Date: 05/23/2024

Re: **Girder Bearing Issue**
Location: Lot 53 Birchwood Grove (Fuquay-Varina, NC)
JDS Project No.: RDU2405382
Date of Inspection: 05/23/24

PROJECT: LOT 53 - BIRCHWOOD GROVE

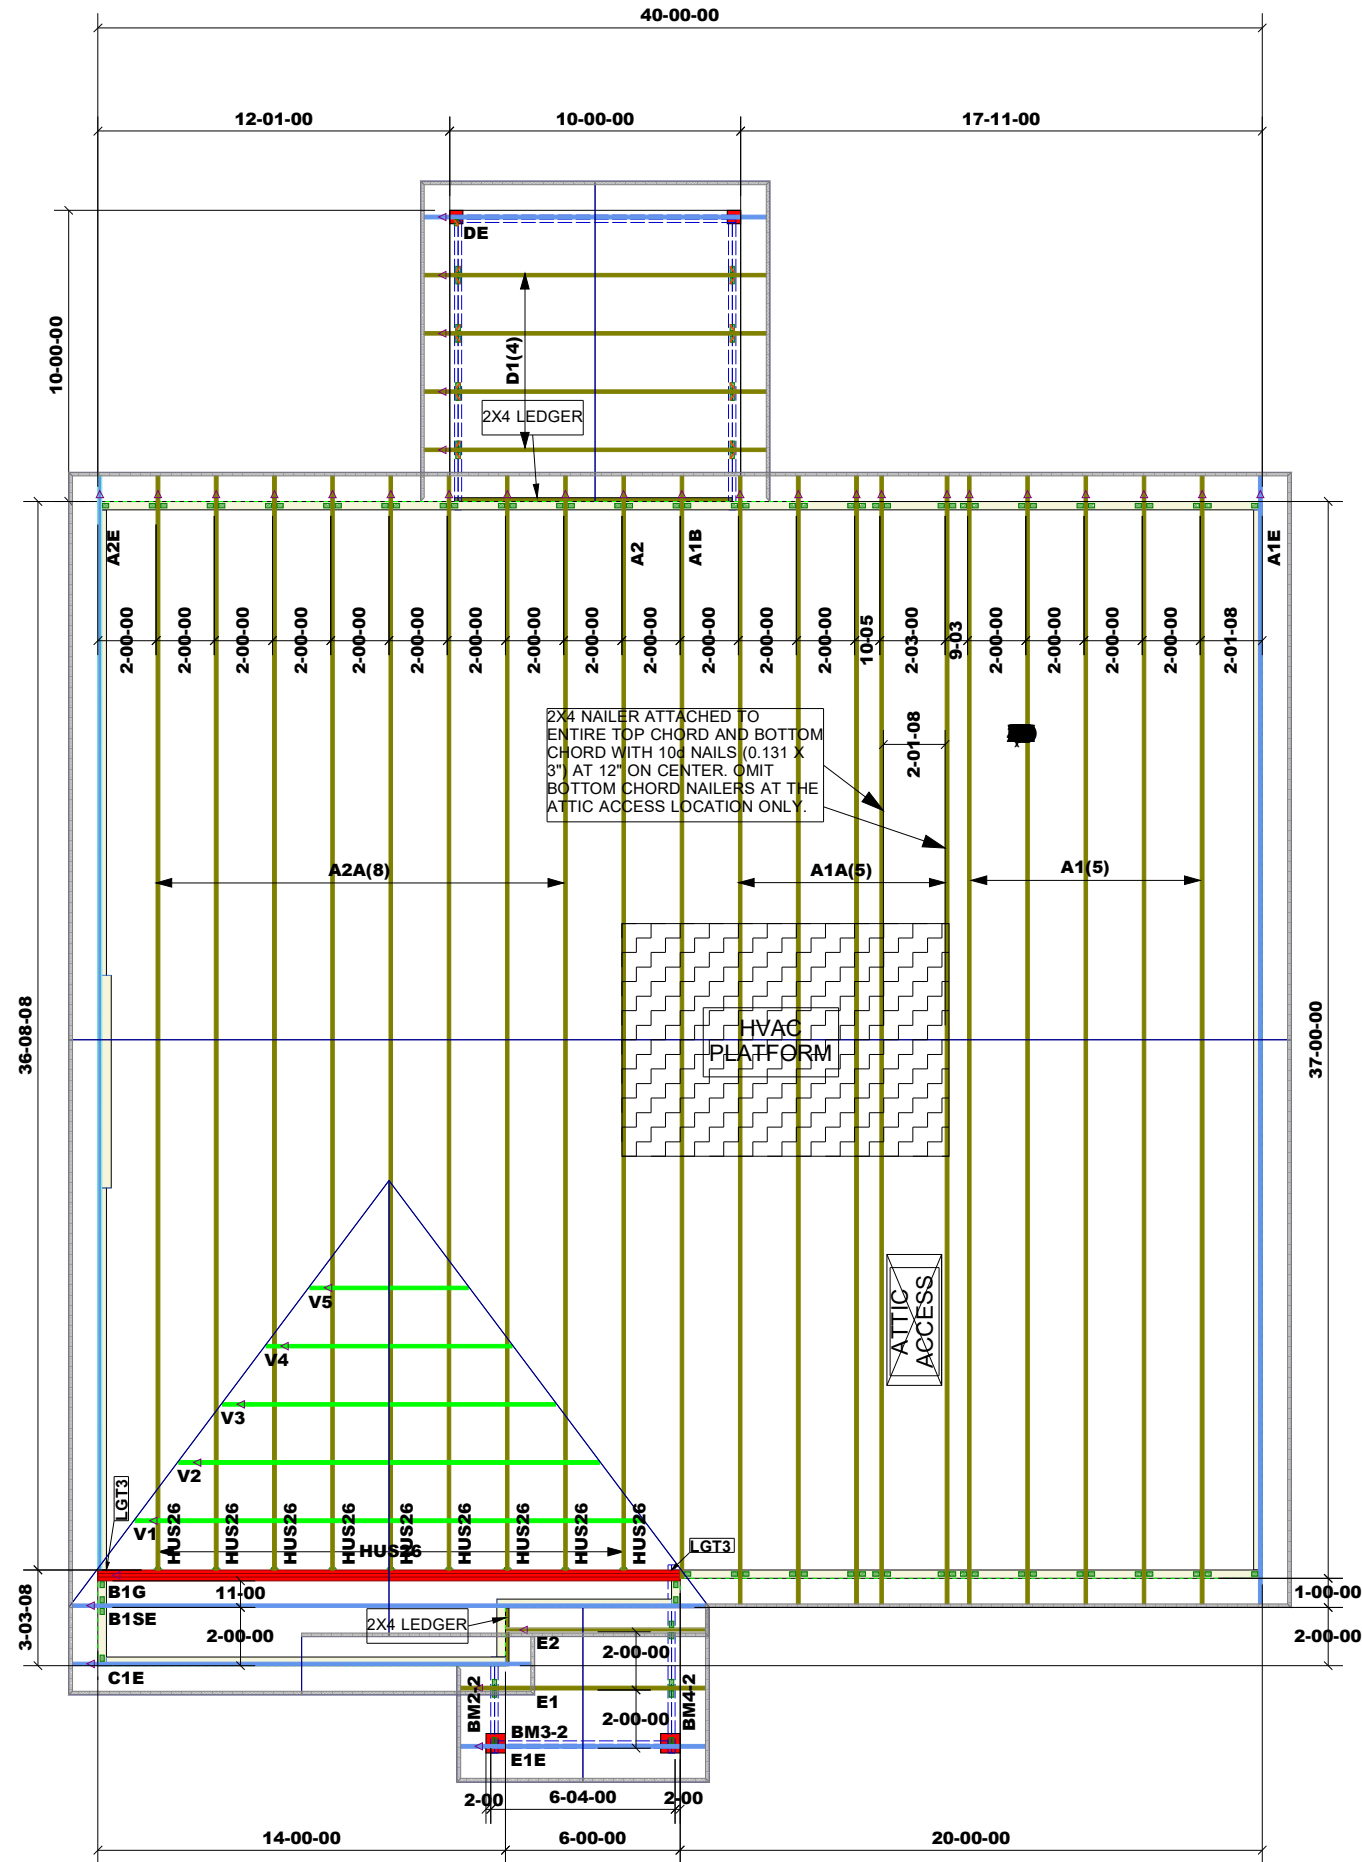
The client requests an evaluation of the B1G (3 ply) girder truss is not fully bearing on the right bearing end in the second-floor front middle bedroom.

Based on our on-site observations and review the client shall install a 6' 2x6 scab on the front right side of the girder truss attached with (3) rows of 10d nails spaced at 6" o.c. with full bearing on the top plate. Then, on top of the nailed-on bearing scab, install another 6' 2x6 on the front right side of the girder truss and attach with (2) rows of 6" long structural screws spaced at 12" o.c. with full bearing on the top plate.
